# CITY OF ALBUQUERQUE

November 19, 2021

**Re: Take 5 Oil Change**  
**6201 Montgomery Blvd. NE**  
**Traffic Circulation Layout**  
Engineer's Stamp 11-11-21 (F18-D030)

TRAFFIC CIRCULATION LAYOUT

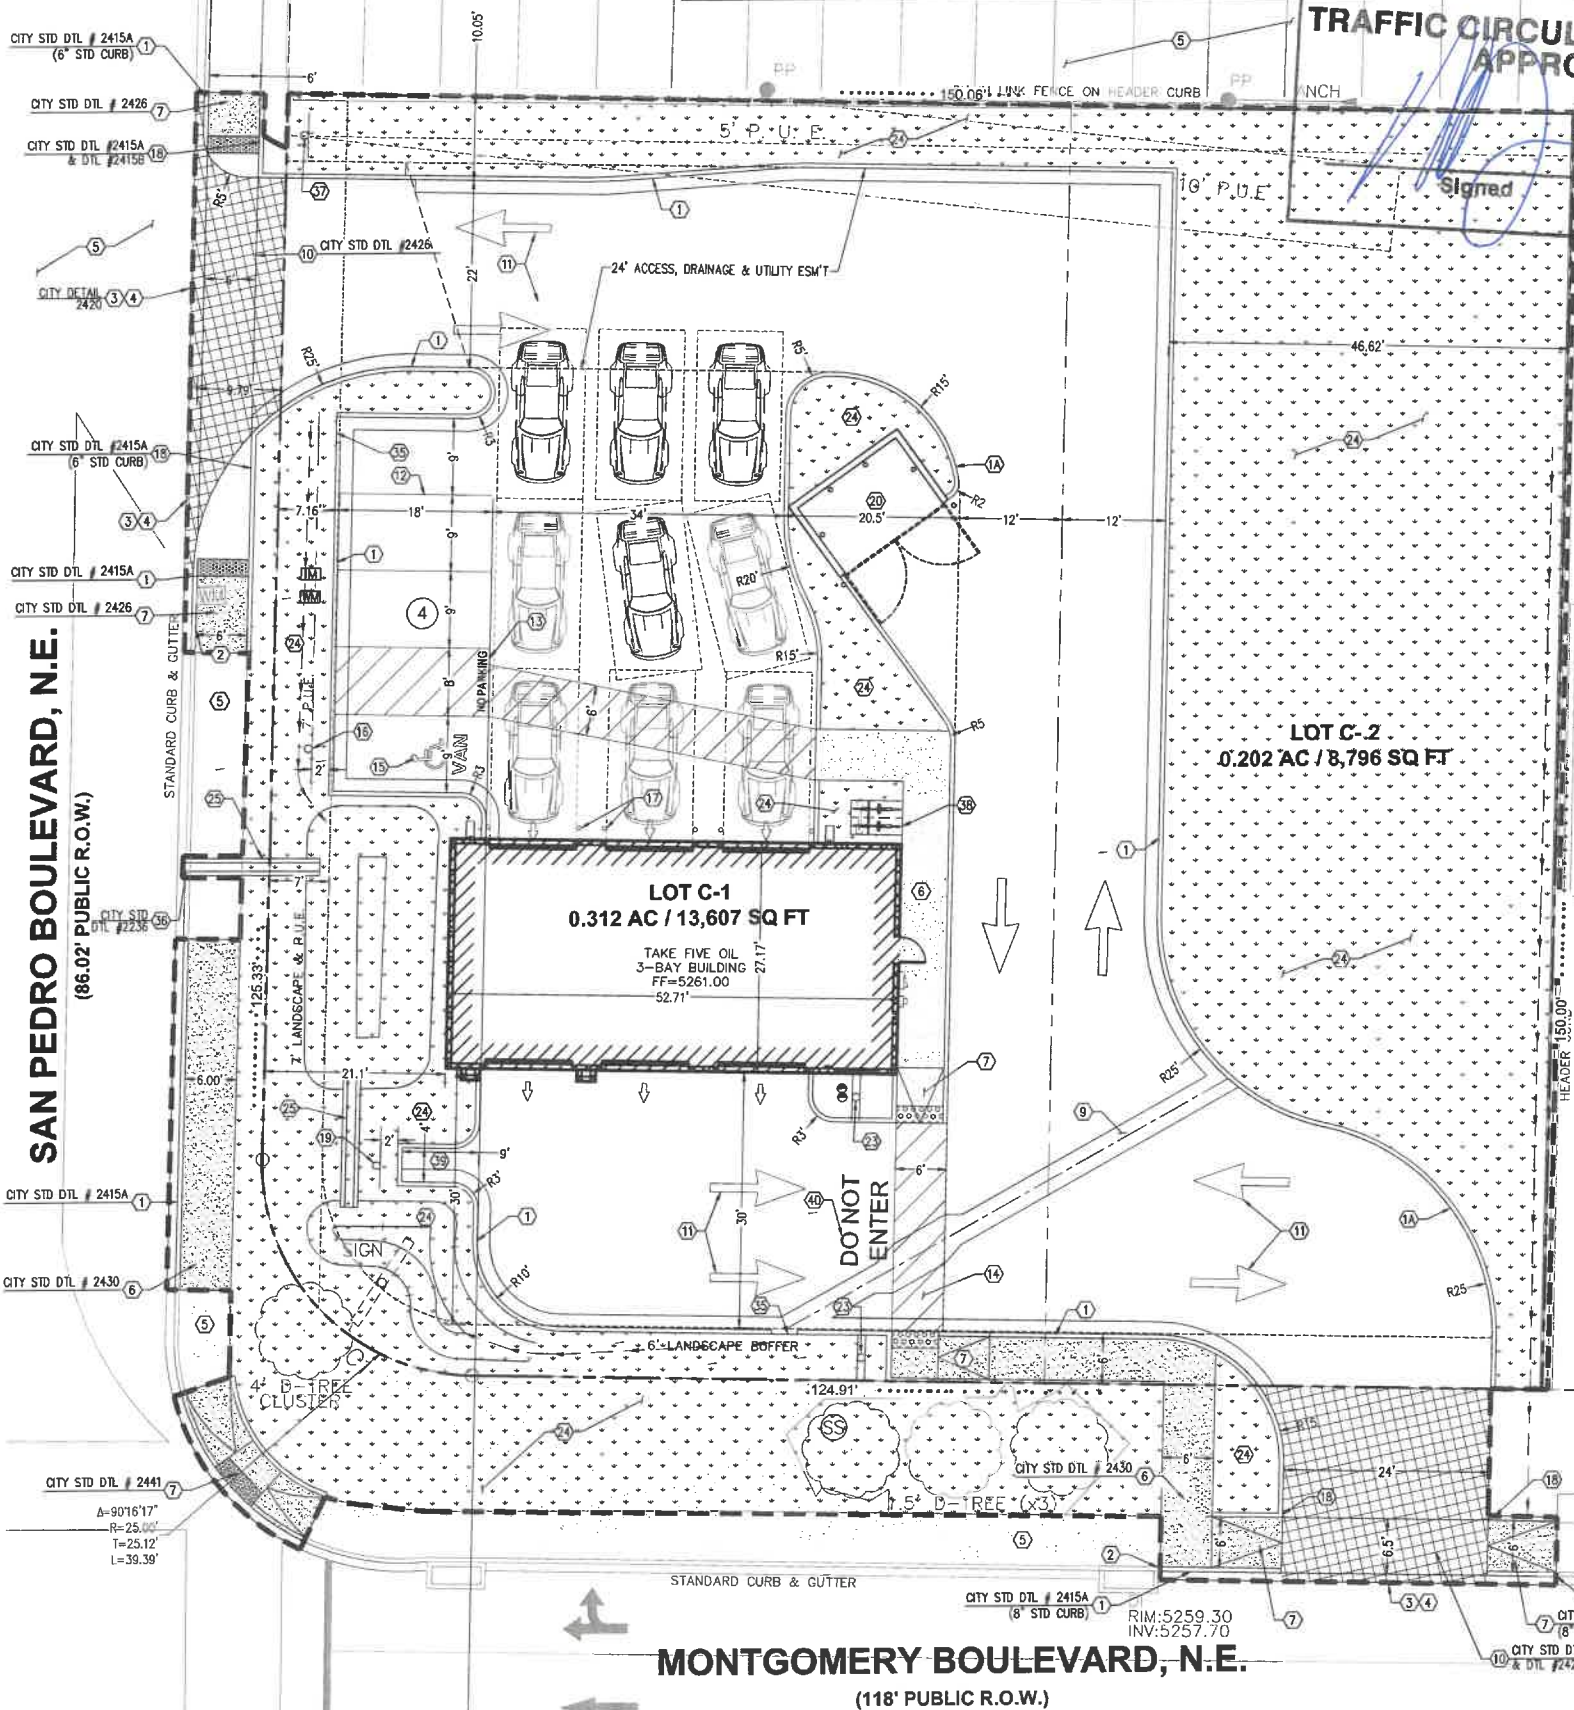
1. List the number of parking spaces required by the IDO as well as the proposed number of parking spaces including bicycle and motorcycle parking.
2. Provide details for all proposed infrastructure, striping, pavement markings, and signage. Either located them inside property or Encroachment agreement is required.

3. Per DPM A 15 ft radius is required for small cars. Radius for delivery trucks, fire trucks, etc. is 25 ft. or larger
4. **Montgomery Blvd. Driveway Access:**

- Driveway entrance needs to be built Per COA standard. Curb Returns rather than drivepads are recommended on Collector and Arterial. Reference COA STD DWG 2426. Montgomery is classified as Principal Arterial and San Pedro is classified as Major Collector.

- The proposed drivepad wing/transition is impacting the ease leg of the ramp and on the west leg there should be a proposed ramp. So either the drivepad design shows wing/transitions or ramps on the lower part of the drivepad.

- It appears the east leg of this driveway access will interfere with the adjacent property. Please address this concern, and provide adjacent property owner agreement.

- Provide driveway access width.
  - Proposed sign and striping should located inside property.
  - Existing sign that locates between trees/landscaping: relocated this sign inside the property, or encroachment agreement is required.

7. Key note 16: it appears there will be a conflict between the proposed ADA sign and the overhang vehicle. Suggestion: provide curb bumper.
8. Please list the width and length for all existing and proposed parking spaces. Some dimensions are not shown.
9. The minimum parking stall dimensions are:

10. Provide ADA Sign and Motorcycle Sign details.
11. The ADA accessible parking sign must have the required language per 66-7-352.4C NMSA 1978 **"Violators Are Subject to a Fine and/or Towing."** Please call out detail and location of signs.

12. The ADA access aisles shall have the words **"NO PARKING"** in capital letters, each of which shall be at least one foot high and at least two inches wide, placed at the rear of the parking space so as to be close to where an adjacent vehicle's rear tire would be placed. (66-1-4.1.B NMSA 1978)

13. ADA curb ramps must be updated to current standards and have truncated domes installed. Using COA std dwg.
14. Motorcycle parking spaces shall be designated by its own conspicuously posted upright sign, either free-standing or wall mounted per the zoning code. Provide sign details.

17. A 1-foot clear zone around the bicycle parking stall shall be provided.
18. Bicycle parking spaces shall be at least 6 feet long and 2 feet wide.
19. Per the IDO, a 6 ft. wide ADA accessible pedestrian pathway is required from the public sidewalk to the building entrances. Please clearly show this pathway and provide details.

20. Per DPM, a 6 ft. wide ADA accessible pedestrian pathway is required from the ADA parking stall access aisles to the building entrances. Please clearly show this pathway and provide details.

24. The minimum drive through lane width is 12 feet with a 25 foot minimum radius (inside edge) for all turns. (A 15 foot radius can be used with an increase in lane width to 14 feet). Please dimension all lane widths and radii.

25. There is a traffic concern with proposed parking stalls versus drive thru lanes. Please explain conceptual strategy.
26. Please provide a sight distance exhibit

27. Show the clear sight triangle and add the following note to the plan: "Landscaping and signage will not interfere with clear sight requirements. Therefore, signs, walls, trees, and shrubbery between 3 and 8 feet tall (as measured from the gutter pan) will not be acceptable in the clear sight triangle.

28. Provide the approved Plat for the new lot line division between Lot 1 and Lot 2 on Site Plan.
29. Curbing should be installed to delineate landscape, parking, and pedestrian ways and identify points of access. Please call out detail and location of barrier curb.

30. Parking areas shall have barriers to prevent vehicles from extending over public sidewalk, public right-of-way, or abutting lots.
31. Please specify the City Standard Drawing Number when applicable.

32. Unused curb cuts must be replaced with sidewalk and curb & gutter. A build note must be provided referring to the appropriate City Standard drawing.

33. Add a note stating "All broken or cracked sidewalk must be replaced with sidewalk and curb & gutter." A build note must be provided referring to the appropriate City Standard drawing.
